Ribble Valley Borough Council
By email

Your ref: 3/2021/0275
Our ref: DC/21/1403v5
Date: 01-MAR-22

Location: Land behind the Dog Inn Market Place Longridge PR3 3RR
Proposal: Proposed erection of 9 new dwellings and associated works

Longditudinal Section along runoff path
1 : 50

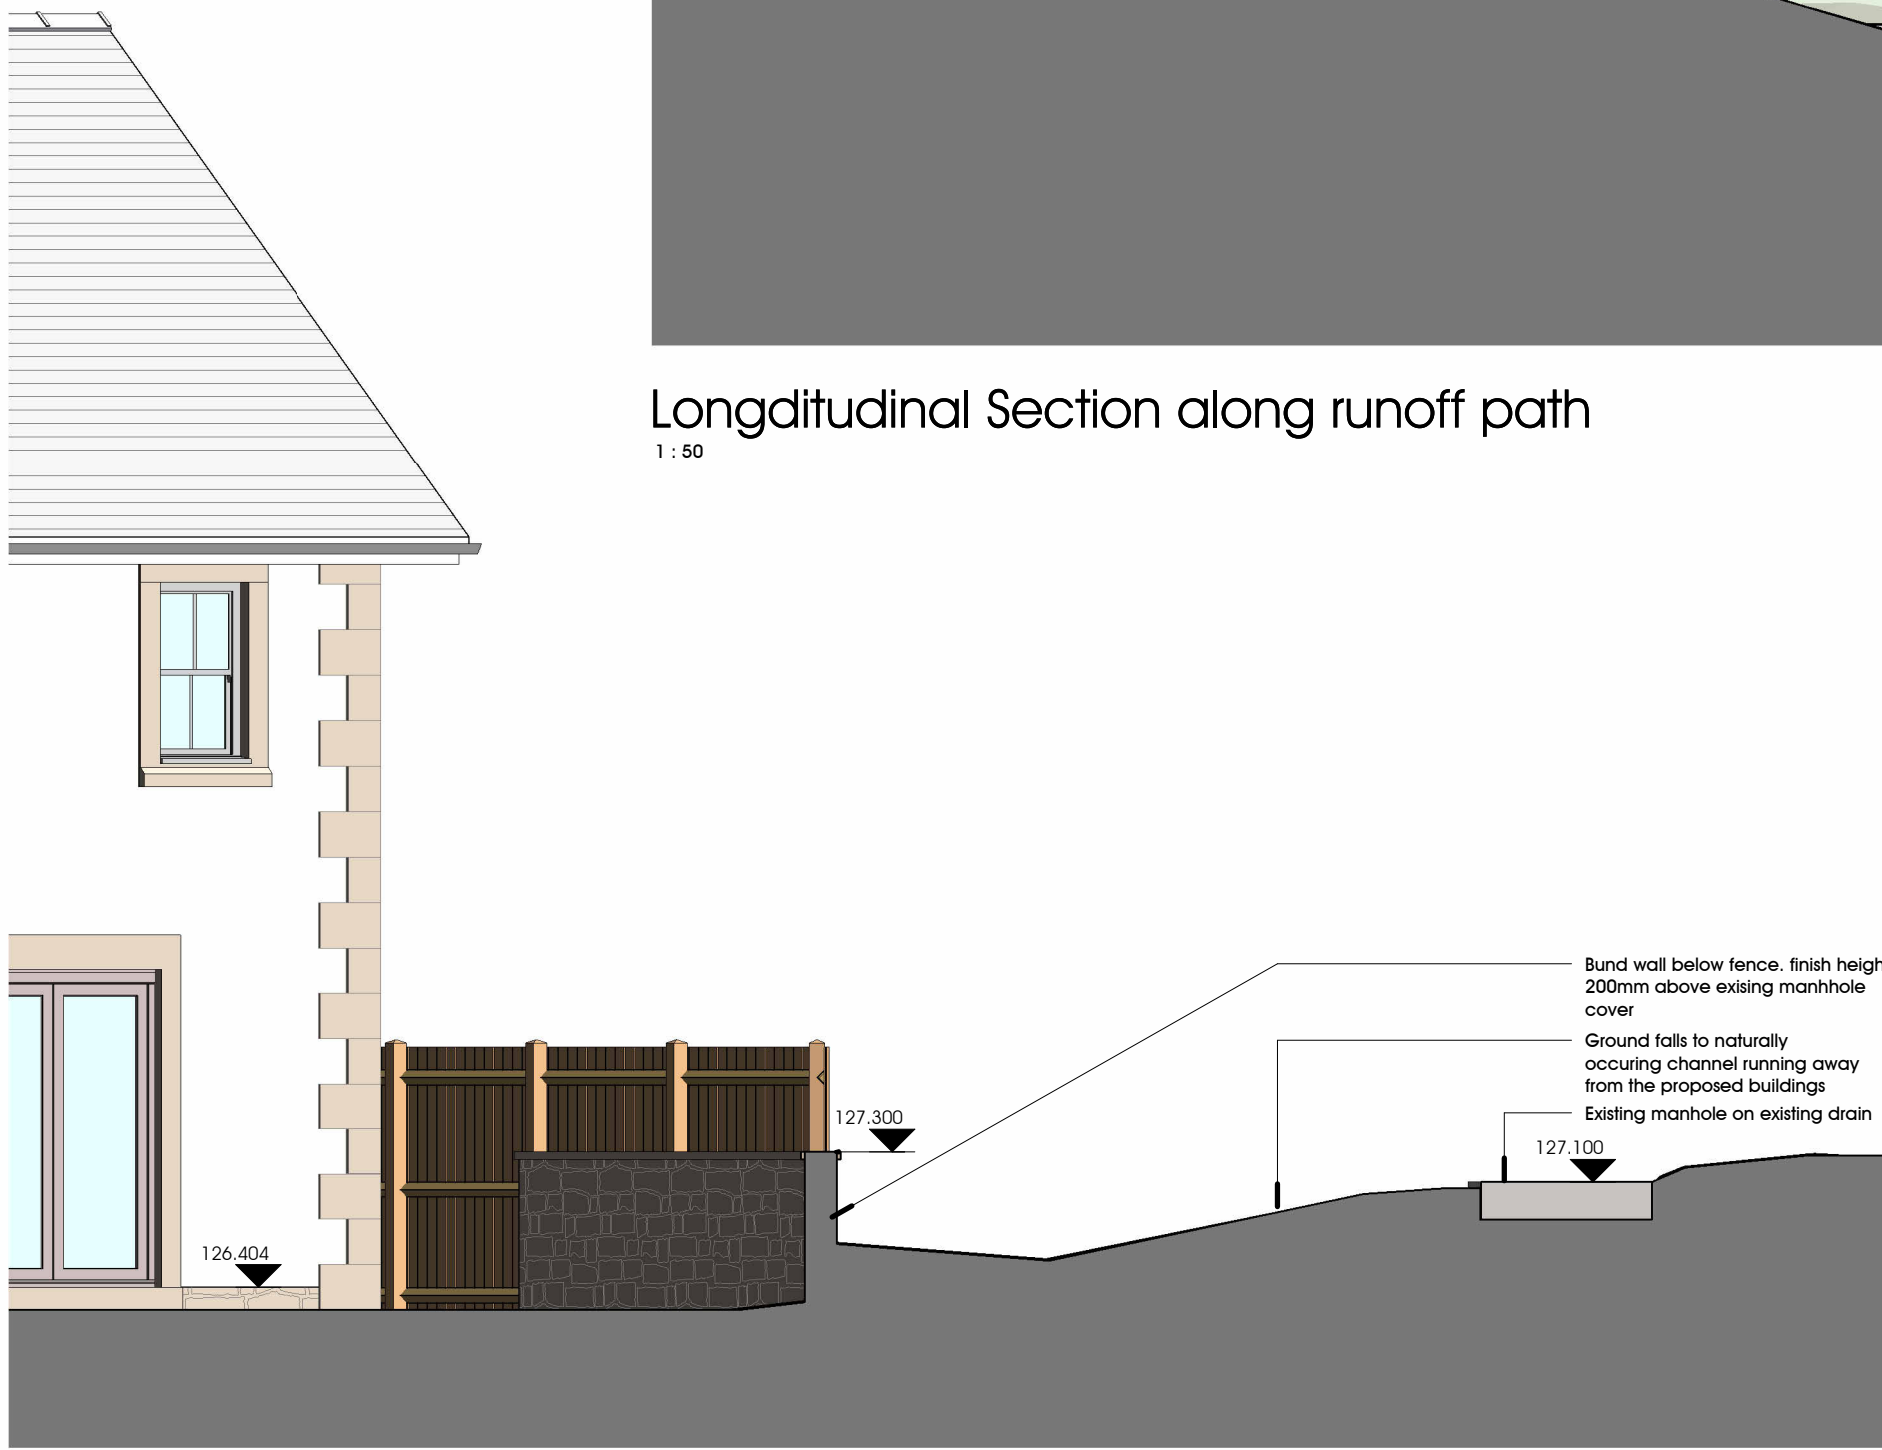
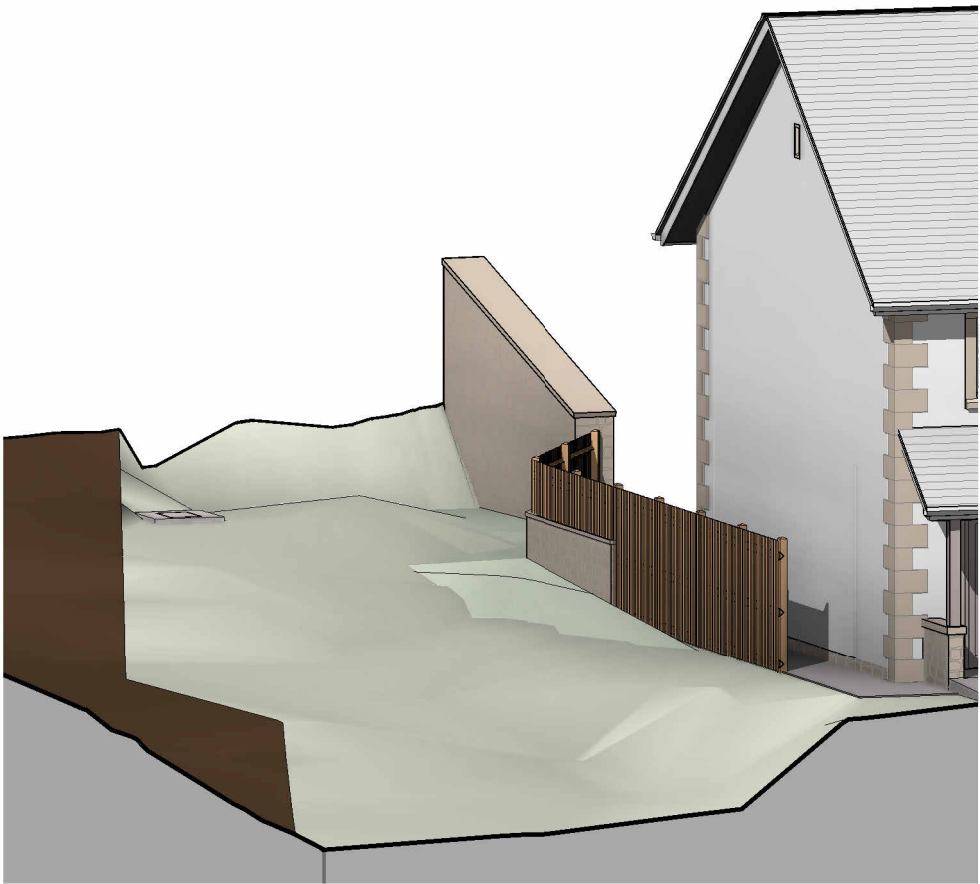
1. It is noted that FFL's for proposed properties are now shown, however no cover or invert levels for the existing and proposed manholes are shown on updated plans. Our previous response requested a detailed drainage plan be submitted, and without this information we are unable to carry out our assessment. We request that the information submitted includes the proposed private drainage runs and connection points for each unit to the proposed drainage systems in order to enable us to complete our assessment of the proposed development.
2. Our previous response requested information on how any exceedance flows will be kept within the road and not continue south towards the existing properties. Please provide a plan

showing kerbs or other physical features which would act to keep exceedance flows within the road.
